WEST SUSSEX COUNTY COUNCIL CONSULTATION

TO:	Arun District Council FAO: Simon Davis
FROM:	Stephen Gee WSCC – Highways Authority
DATE:	18 September 2026
LOCATION:	Land at Sunnyside Nurseries Yapton Road Barnham
SUBJECT:	BN/73/26/OUT Outline planning (with some matters reserved except access) for up to 190 No. dwellings including informal and formal public open space, landscaping, drainage, and other associated works. This application is a Departure from the Development Plan, affects a Public Right of Way and may affect the setting of listed buildings. More information received on 3rd September 2026.
DATE OF SITE VISIT:	Officer Familiar with site and 6/7/26 (Noting road closure)
RECOMMENDATION:	No Objection

Following further discussions with the applicant's transport consultant, a transport technical note dated August 2026 has been provided to address comments raised in the initial WSCC Highways consultation response.

PROPOSED
ACCESS ARRANGEMENT

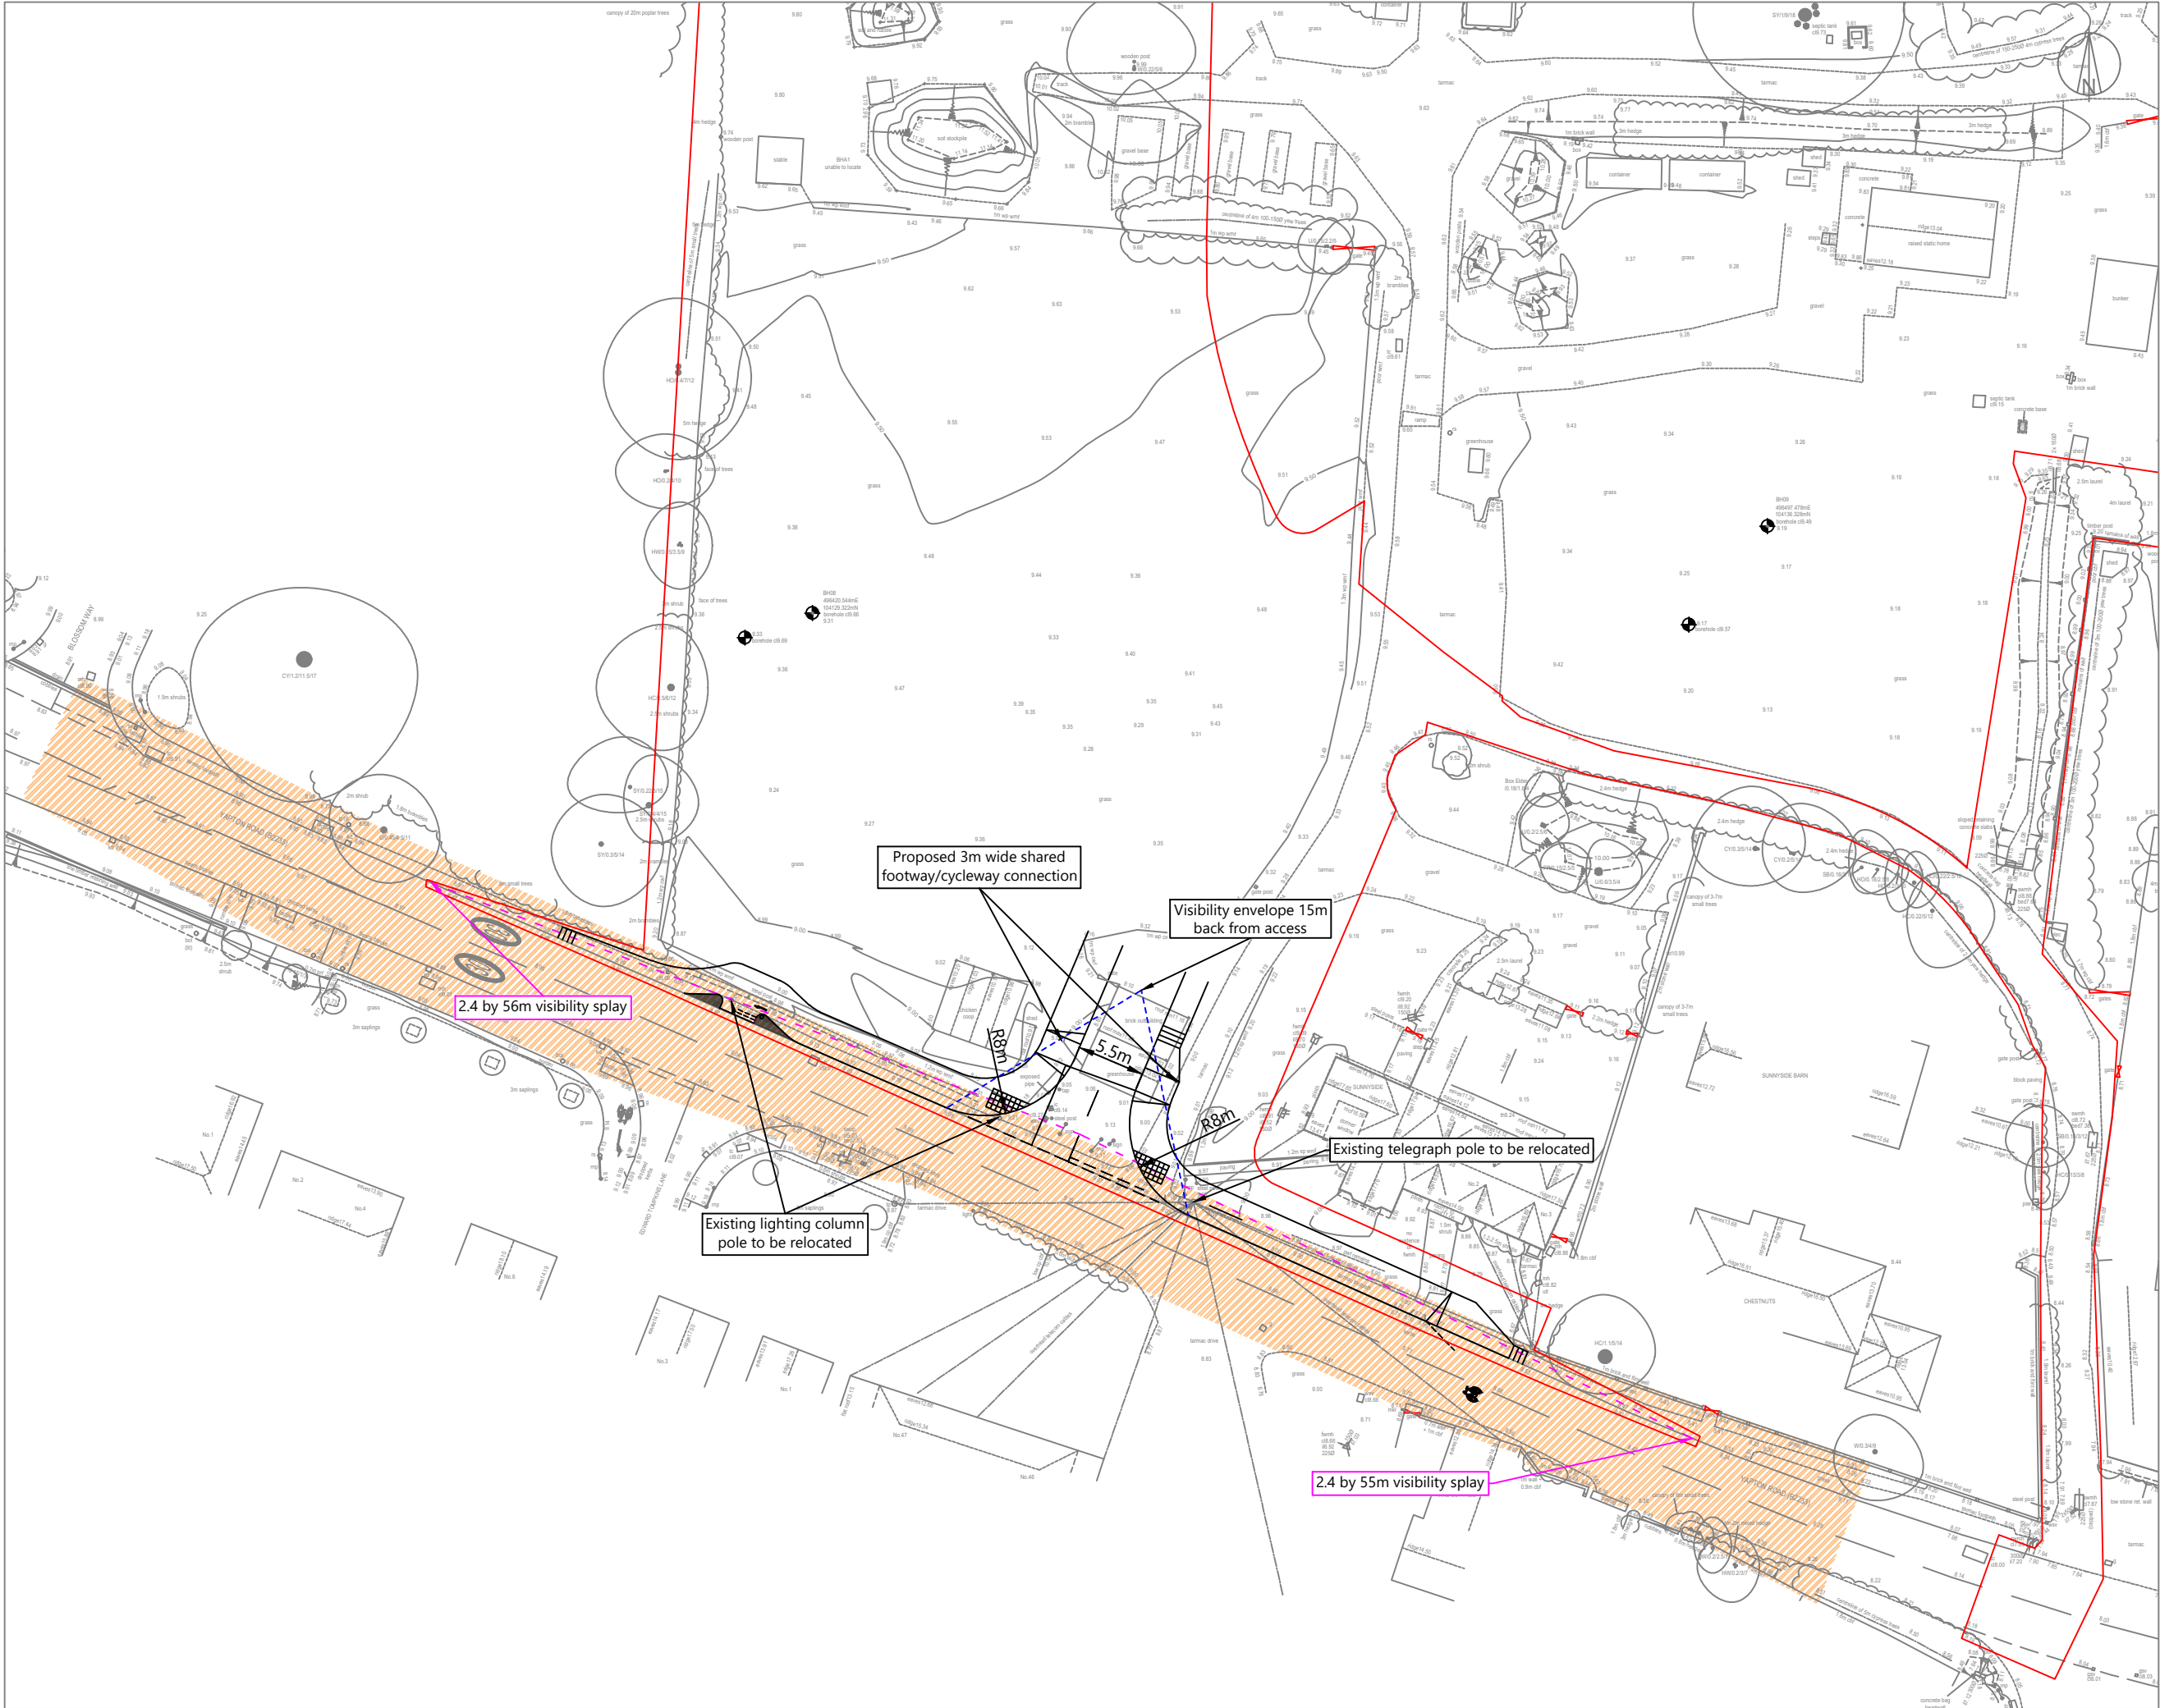
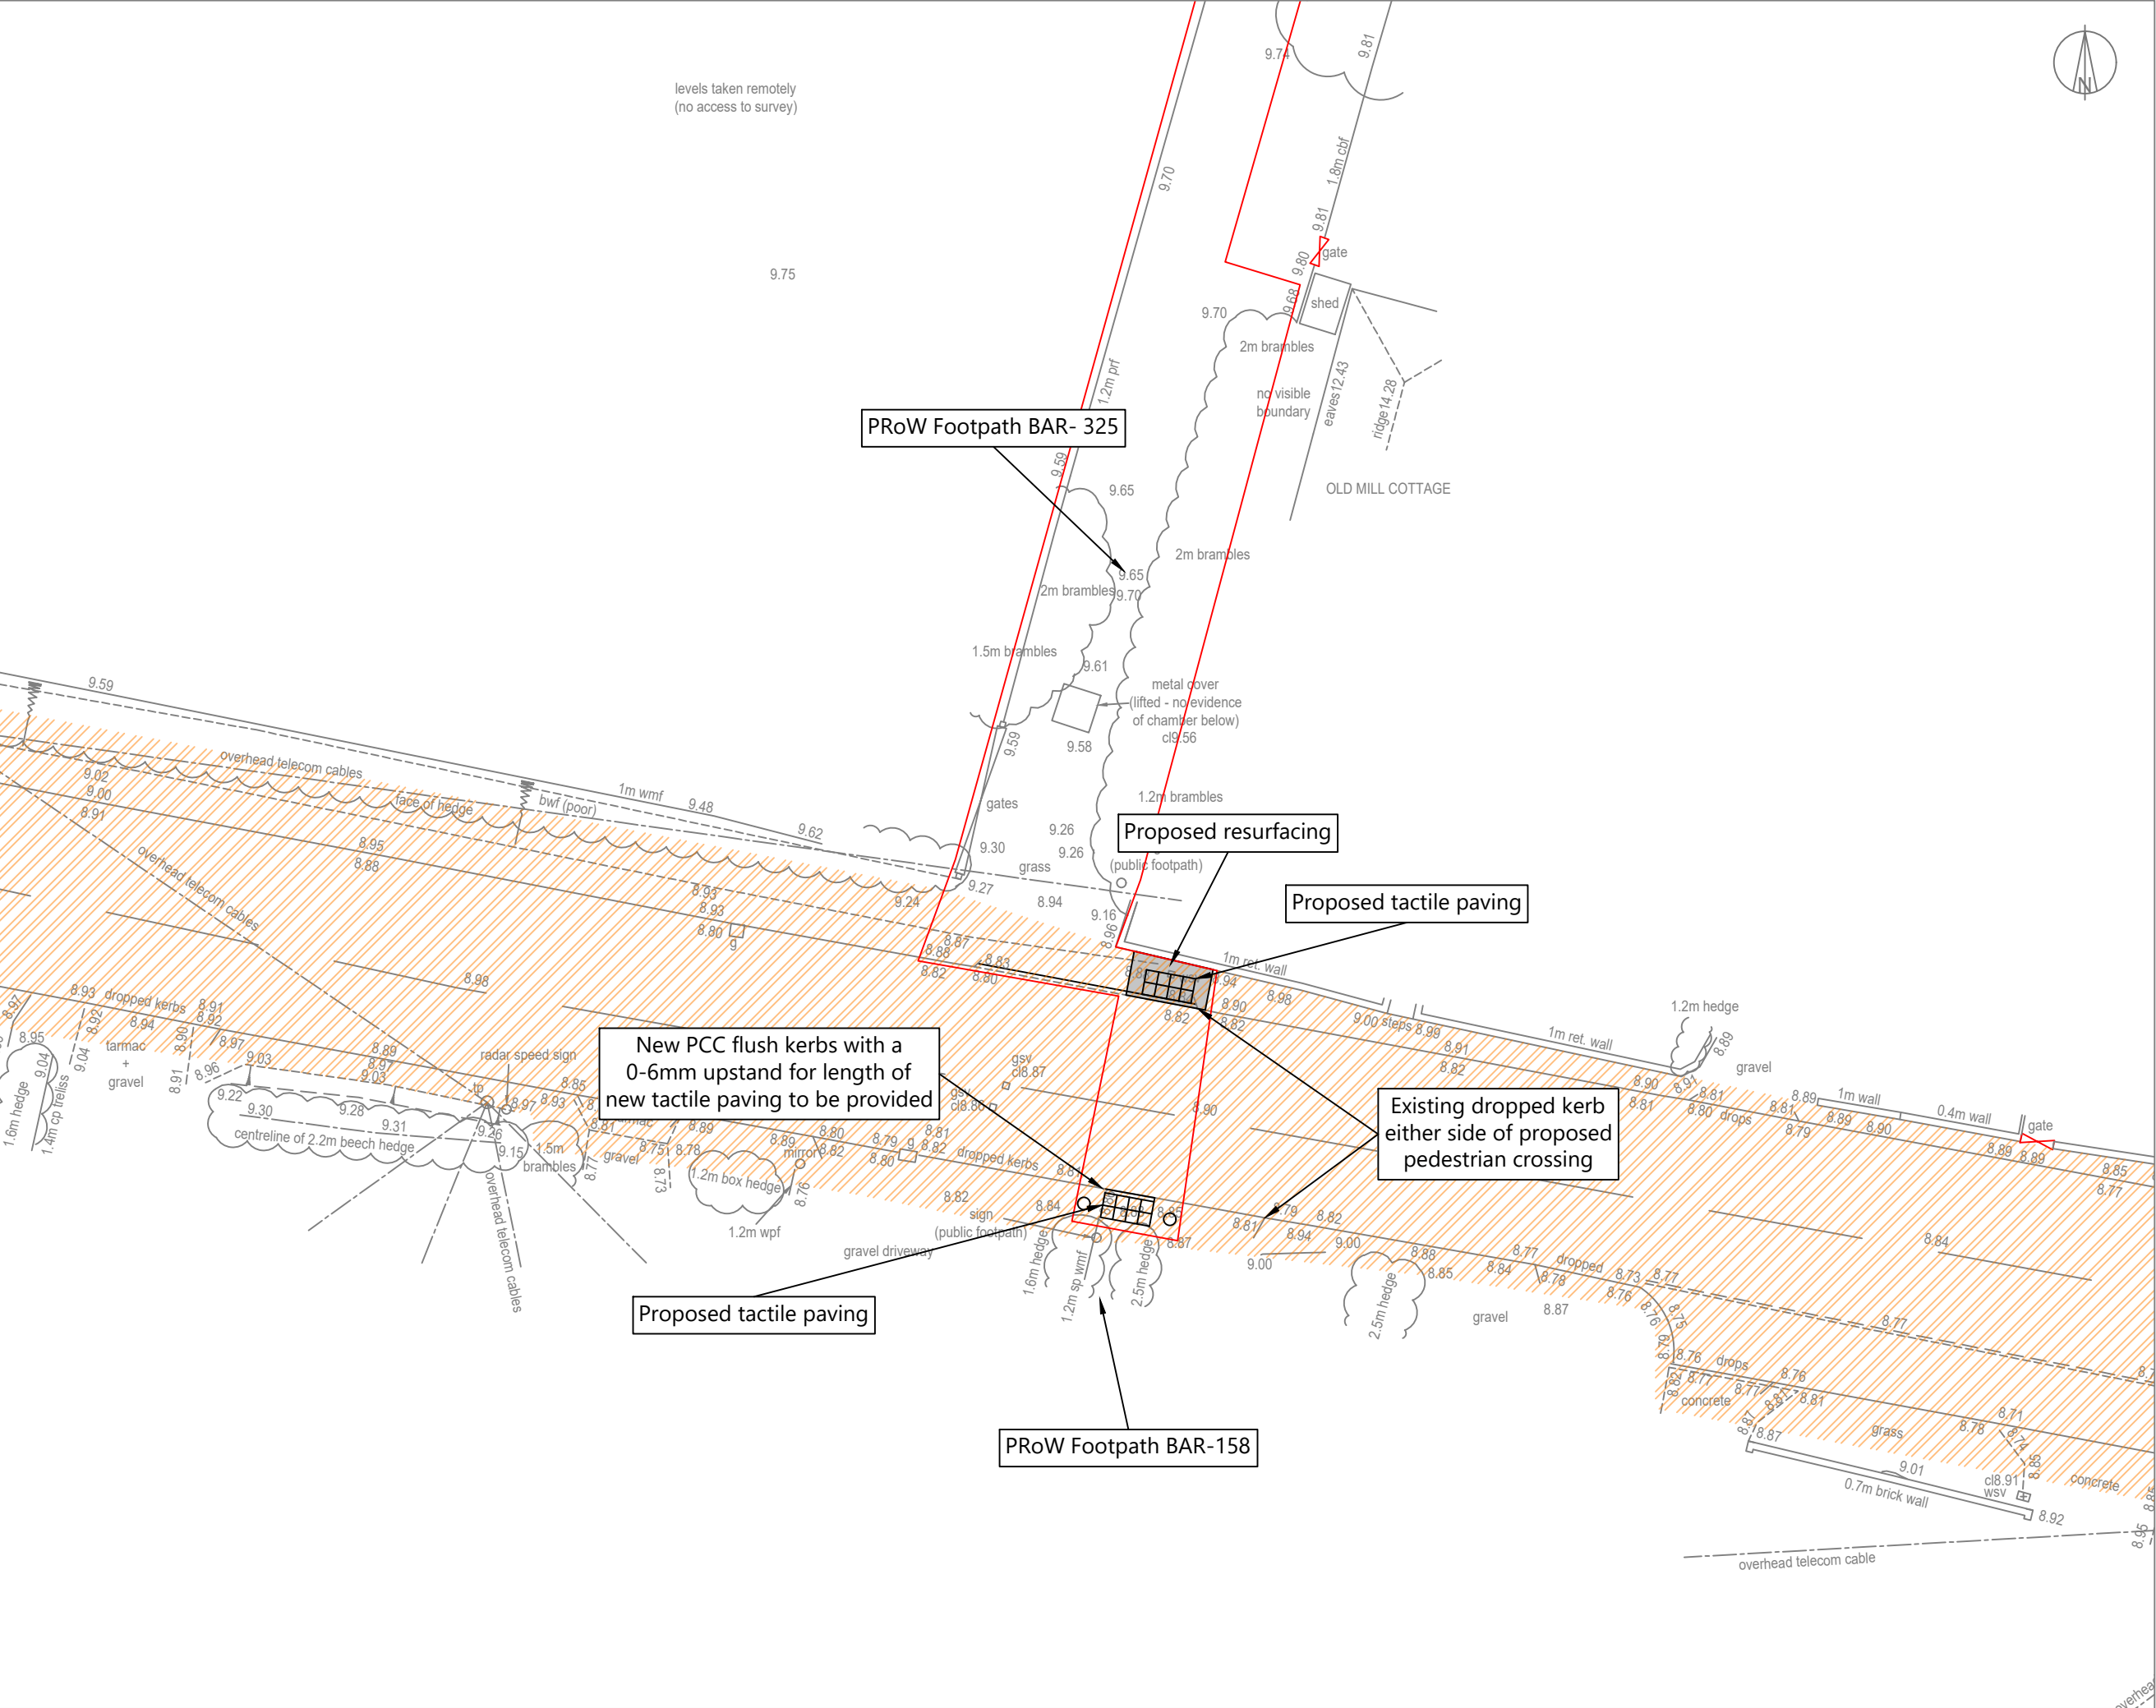
WSCC considered that the shared use elements should be removed from the site access proposals and replaced by a 2m wide footway. The design of the existing shared use provision on the southern side of the carriageway makes any additional cycle provision on the north side difficult to implement in a coherent manner.

No part of the development shall be first occupied until such time as the vehicular access serving the development has been constructed in accordance with the details shown on the drawing titled Proposed Access Arrangements REV E sheets 1 and 2 and numbered 2413 - 09.

Figure 2 – Swept path example, current situation (ignoring bollard)

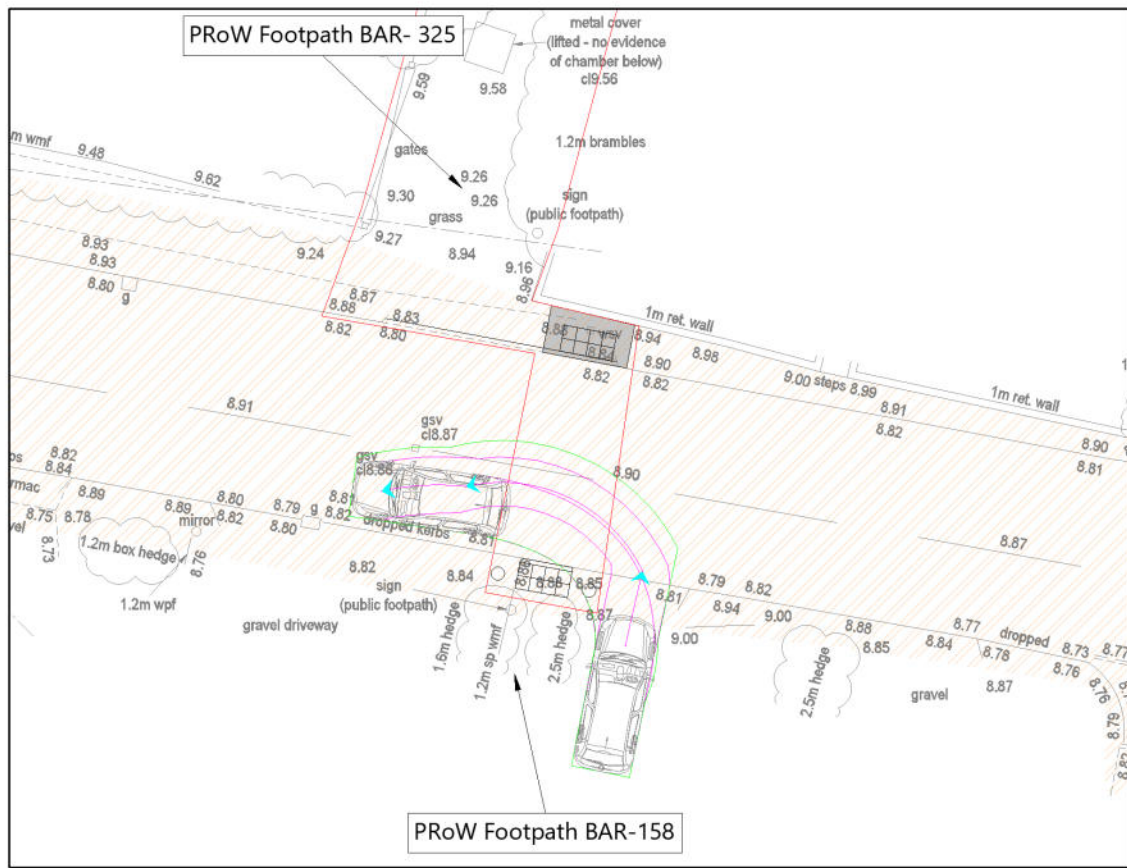
The designers response has been completed and agreed actions developed. Additional information including vehicle tracking for the property adjacent to the proposed bollards on the eastern side of Footpath BA-158 has been provided to support the agreed actions.
